A417 Missing Link ExA Questions 2 – comments by G Lambrick MA FSA MCIfA

2.5 Draft Development Consent Order

2.7. Heritage

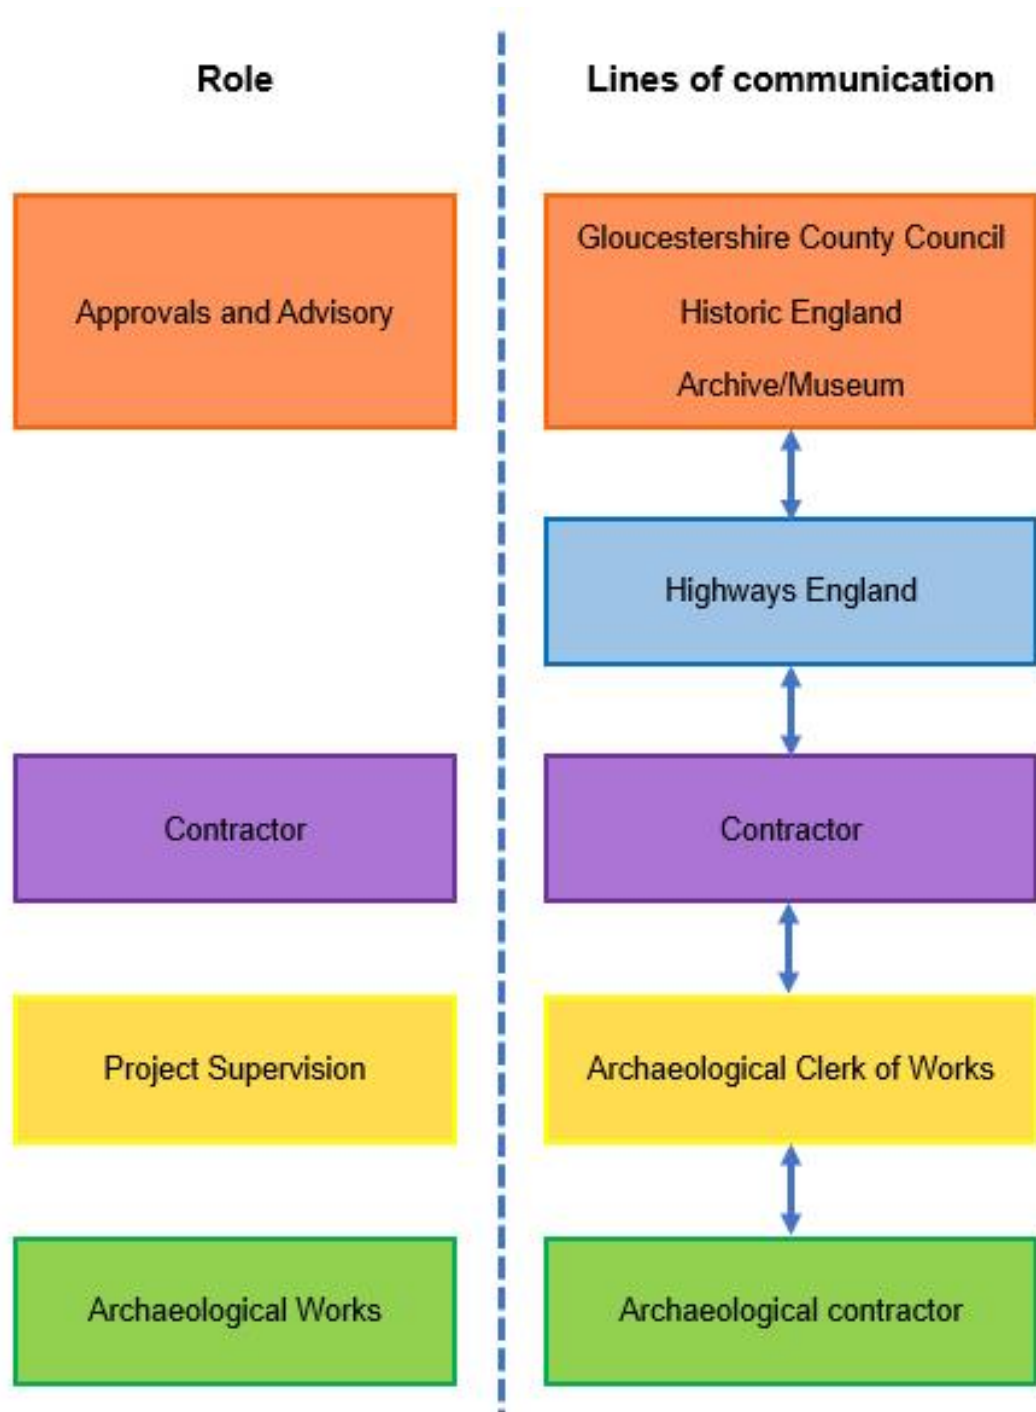
46. The 'programme' for archaeological works as presented in the draft DAMS (section 3.16) is not a programme but an aspiration of how different kinds of archaeological

works would be fitted in. This is hardly adequate for the ExA to judge whether in fact the proposed overall timescale could be delivered or what would happen if not.

Table D-1 Archaeological potential and research questions

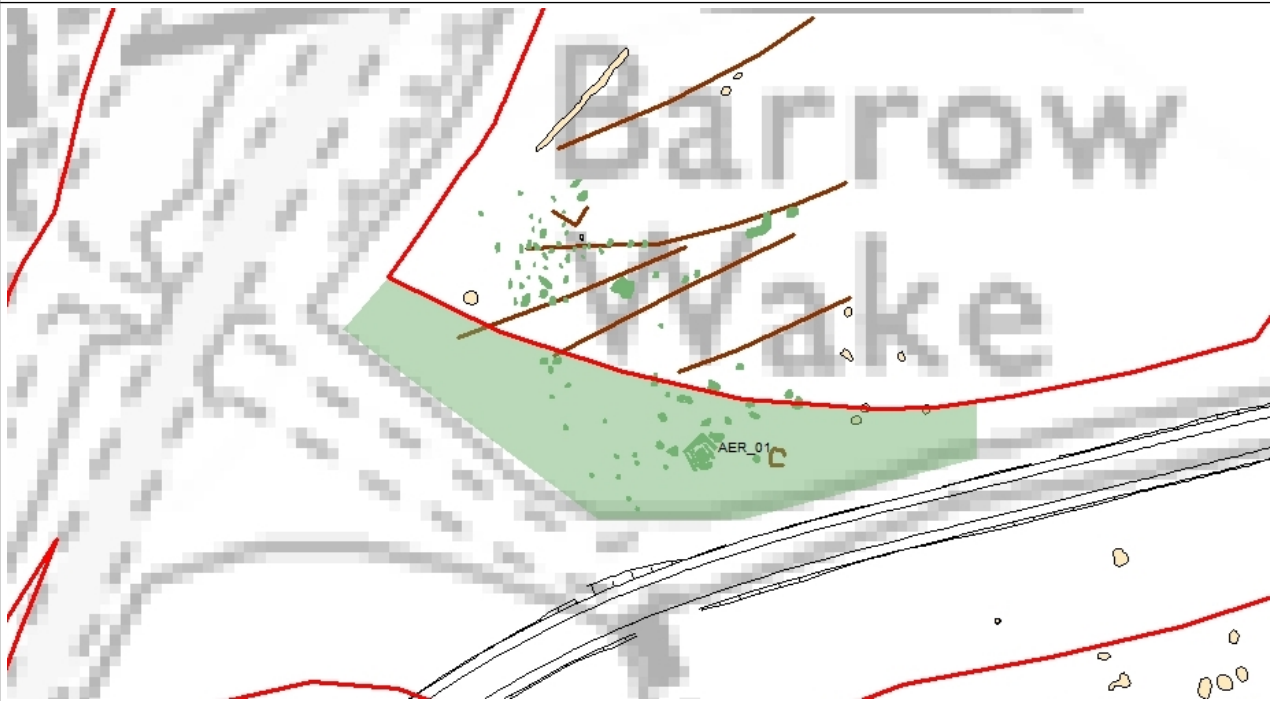
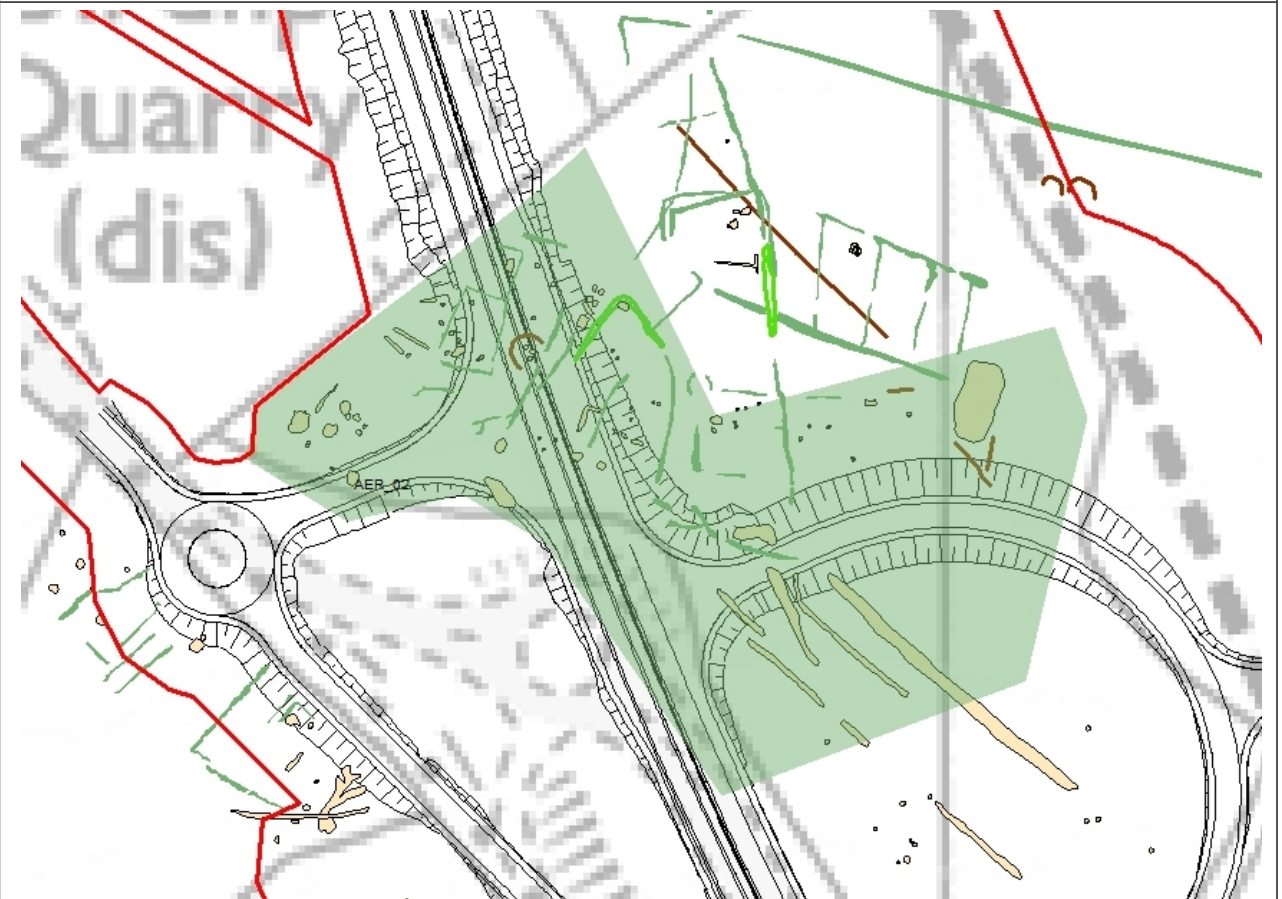
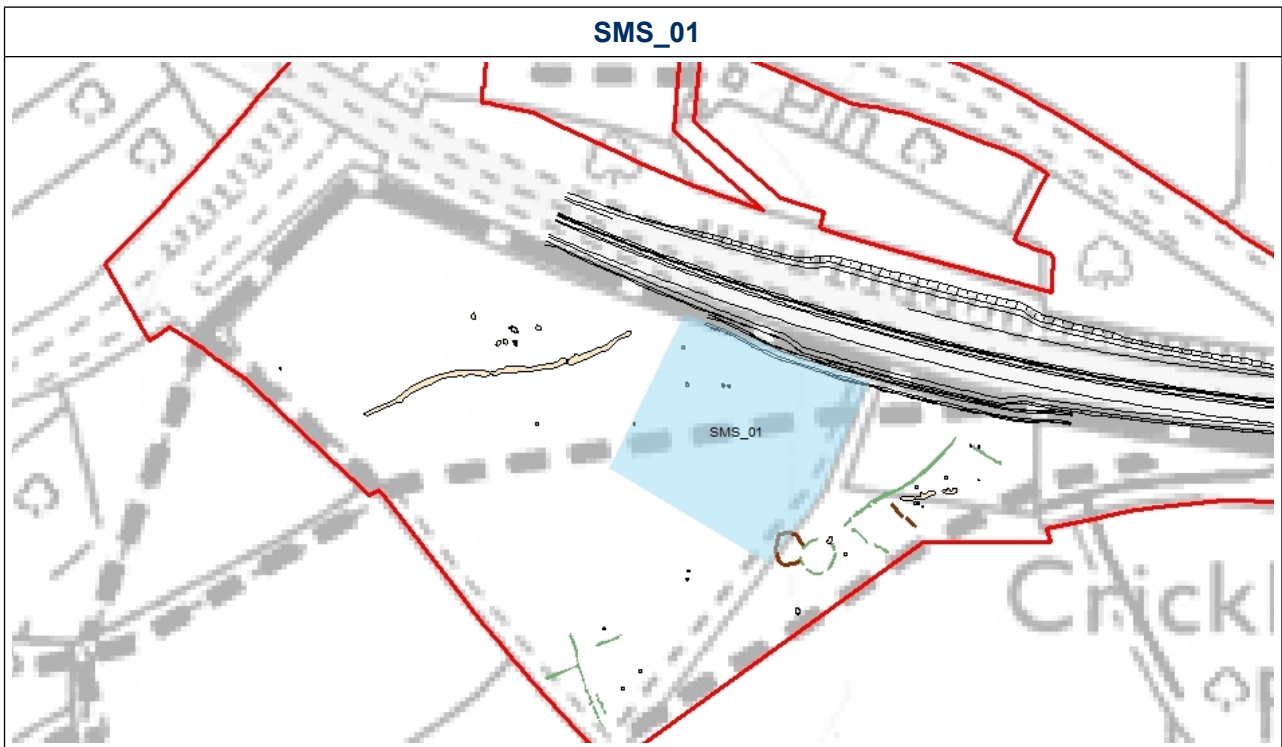
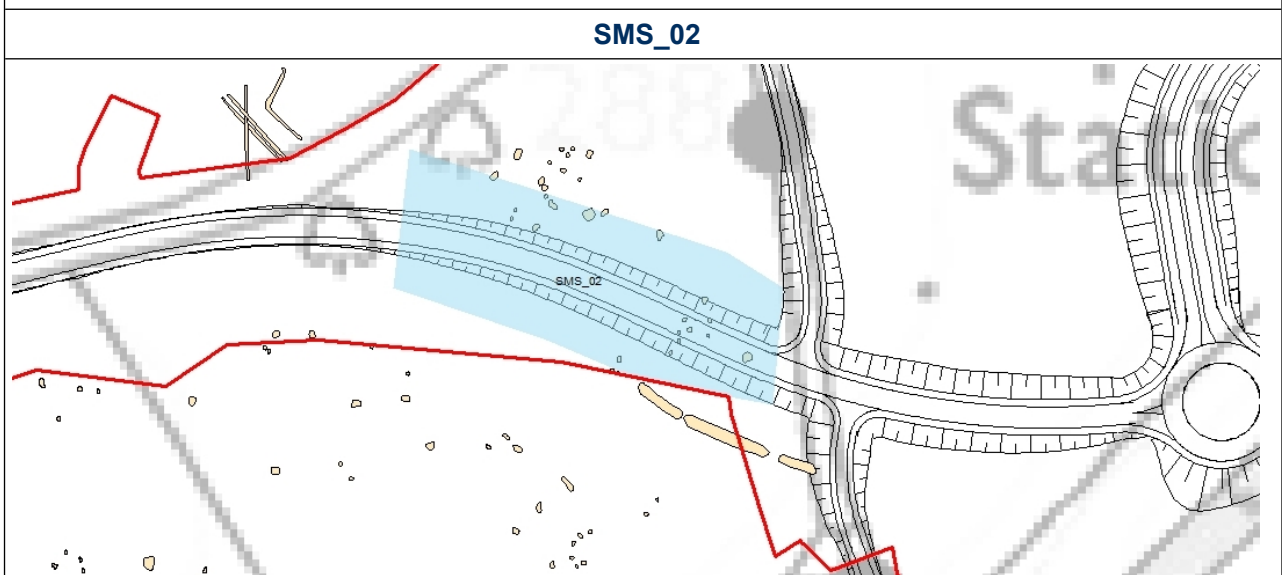
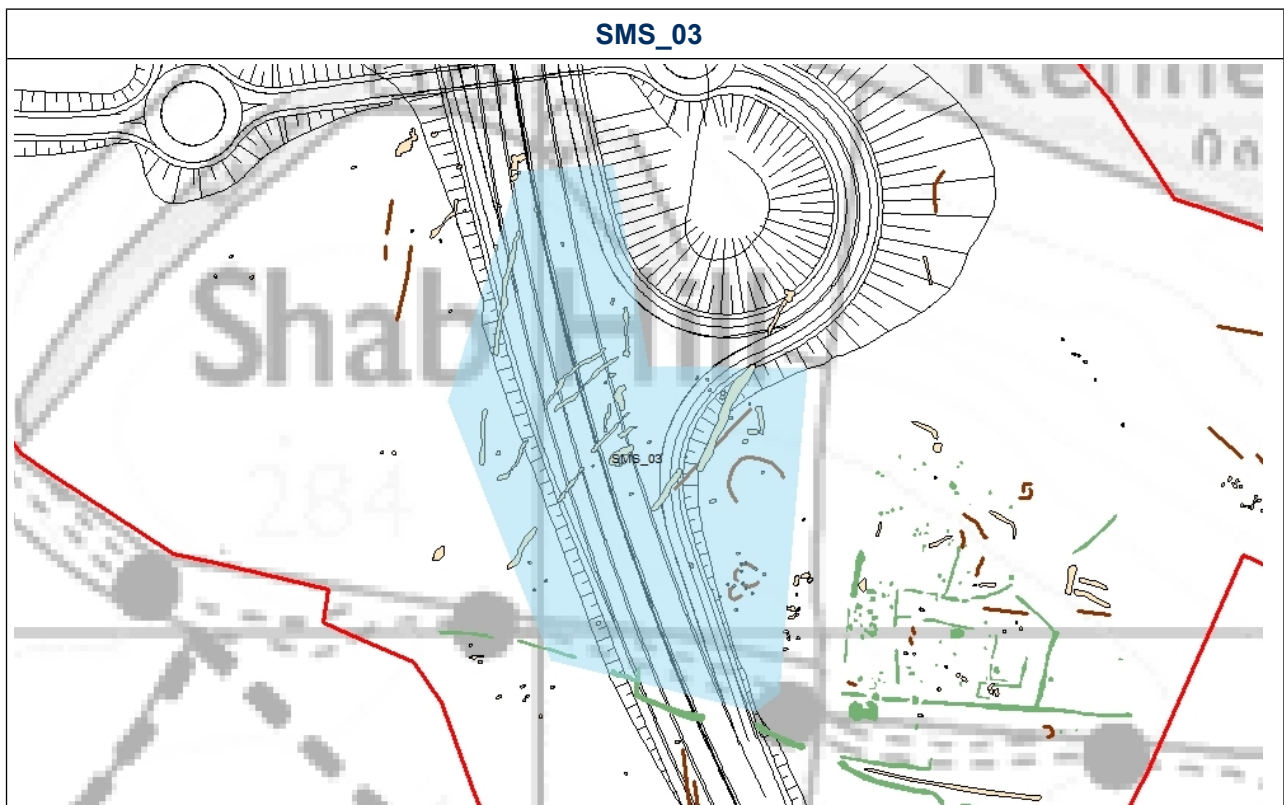
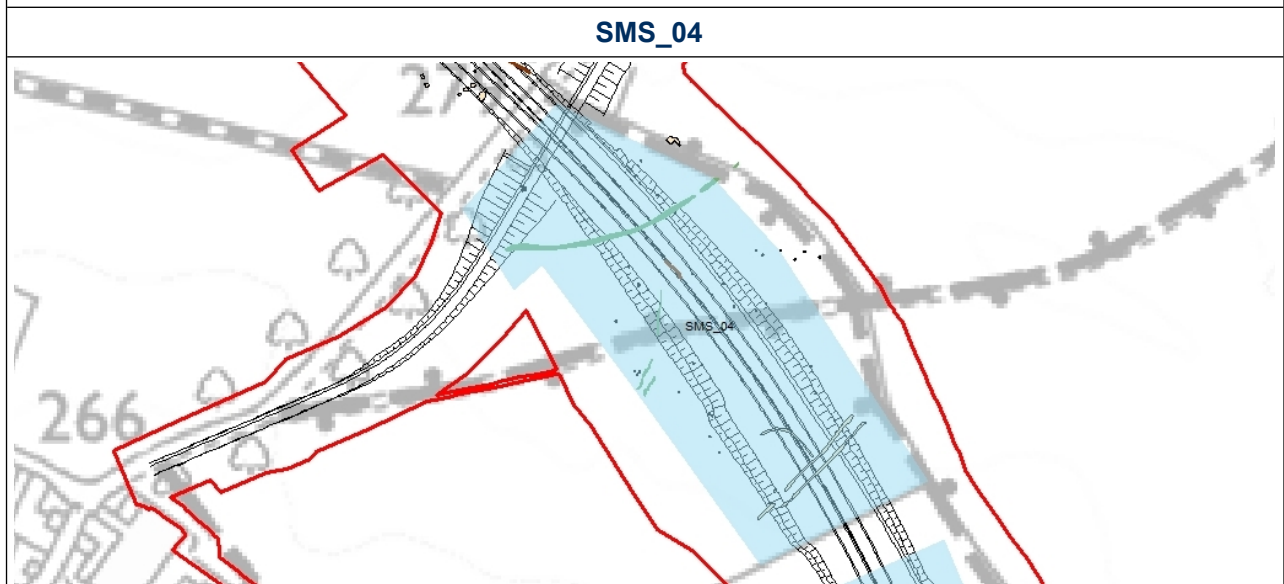
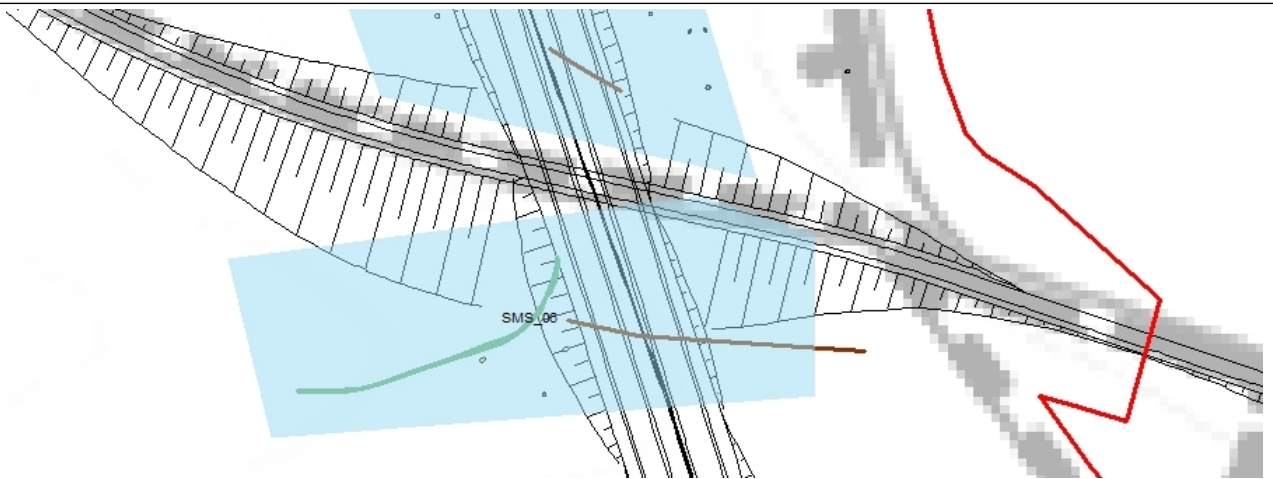
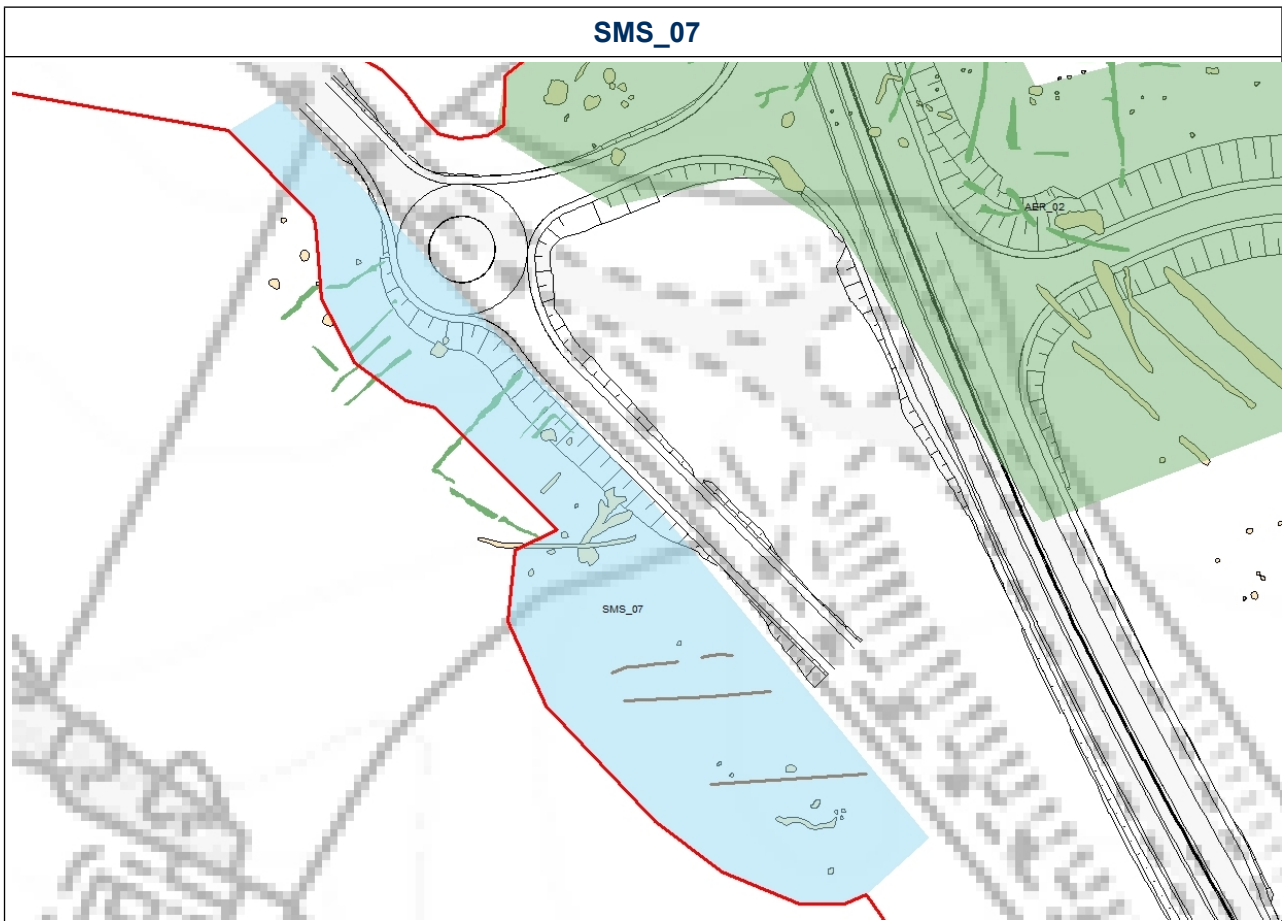
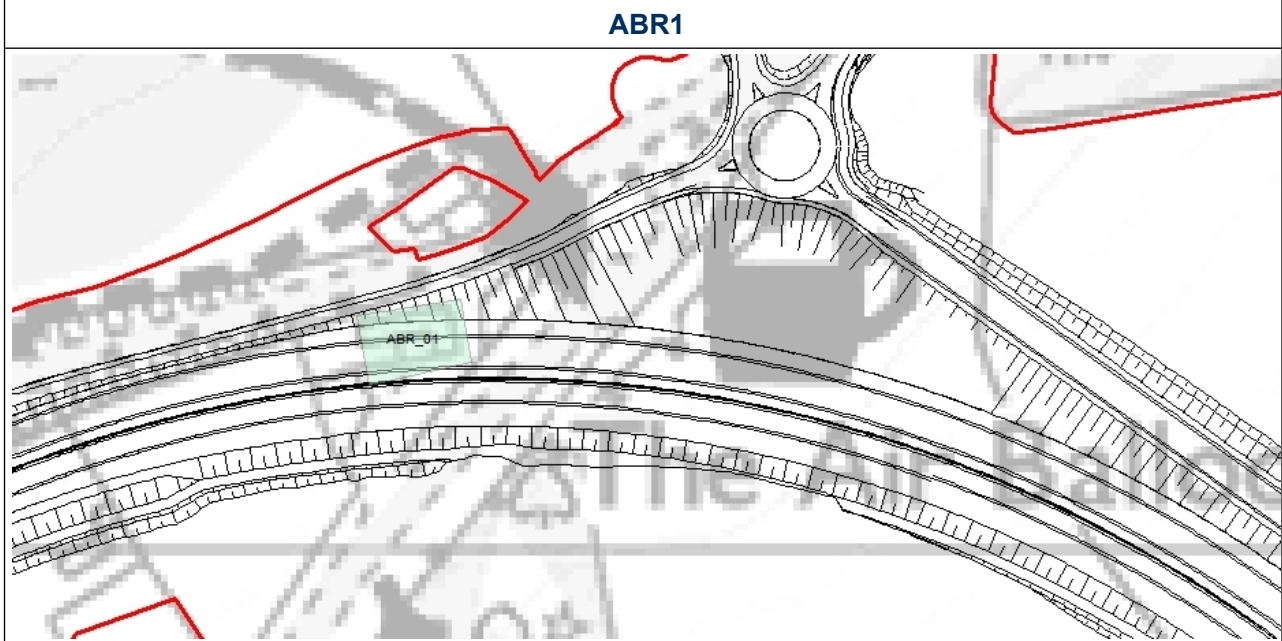
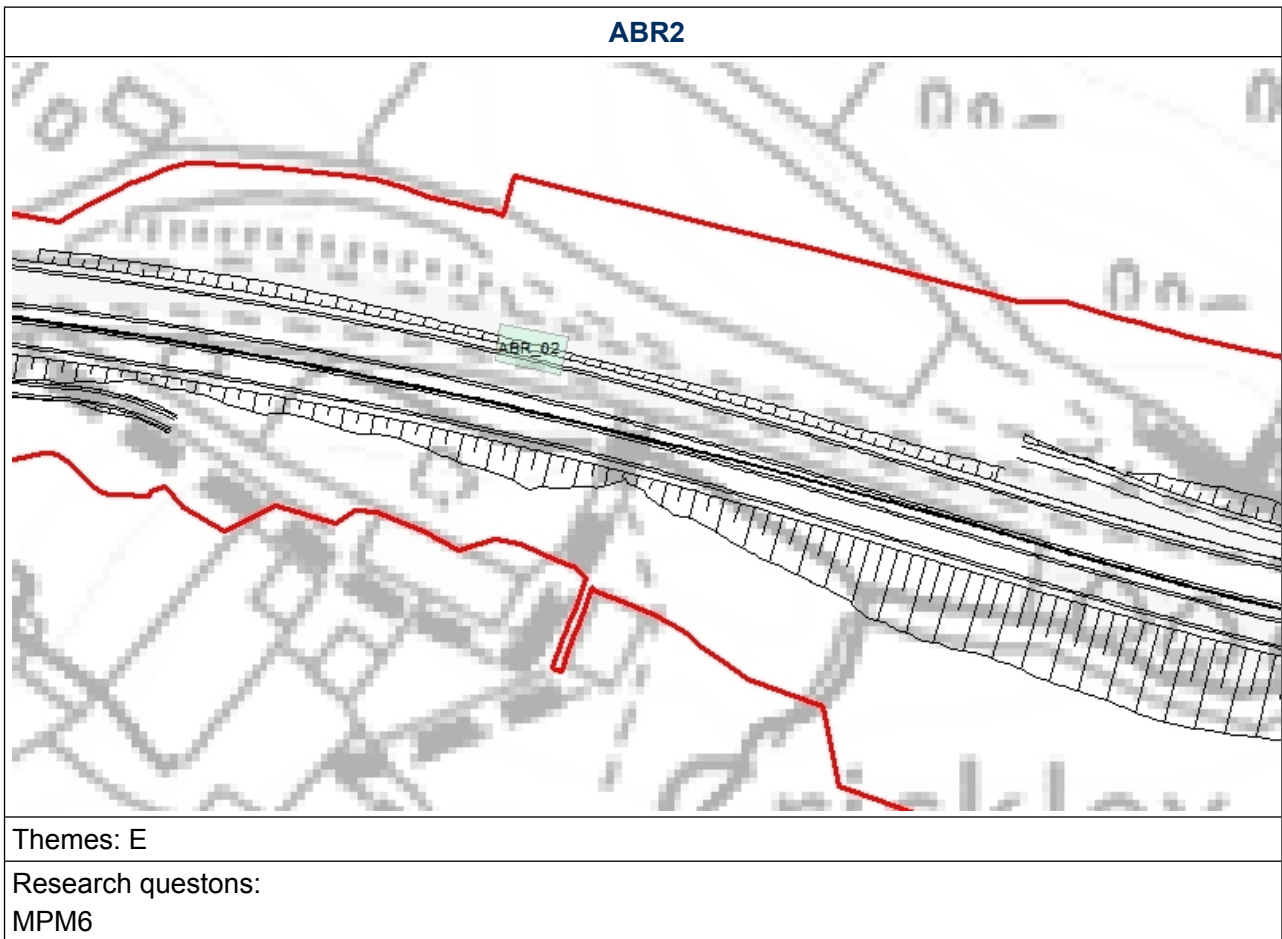
22. Currently, the areas earmarked for investigation in the draft DAMS/OWSI (*Appendix D Applying the research agenda*) are stated as only being ‘indicative,’ on the basis that

It will be revised and updated at detailed design (following the completion of all trial trenching) to include areas proposed for watching brief, retention within the scheme, or no further archaeological work.

23. Leaving this till detailed design stage is wholly inadequate as the basis for accepting the draft DAMS/OWSI as an adequate basis to meet NSPNN requirements, nowhere near reflecting overall seriousness of the scale of impact as reported in the ES Chapter 6 paras 6.10.15 and 6.10.16 (quoted above).

24. This is especially serious given in respect of areas of likely or possible national significance (see below). Especially obvious is the absence of any provision for investigating the area of high potential for the identified well preserved Iron Age settlement at the E foot of Crickley Hill and other areas already identified as having high potential through trial trenching in areas subject to ground disturbance.
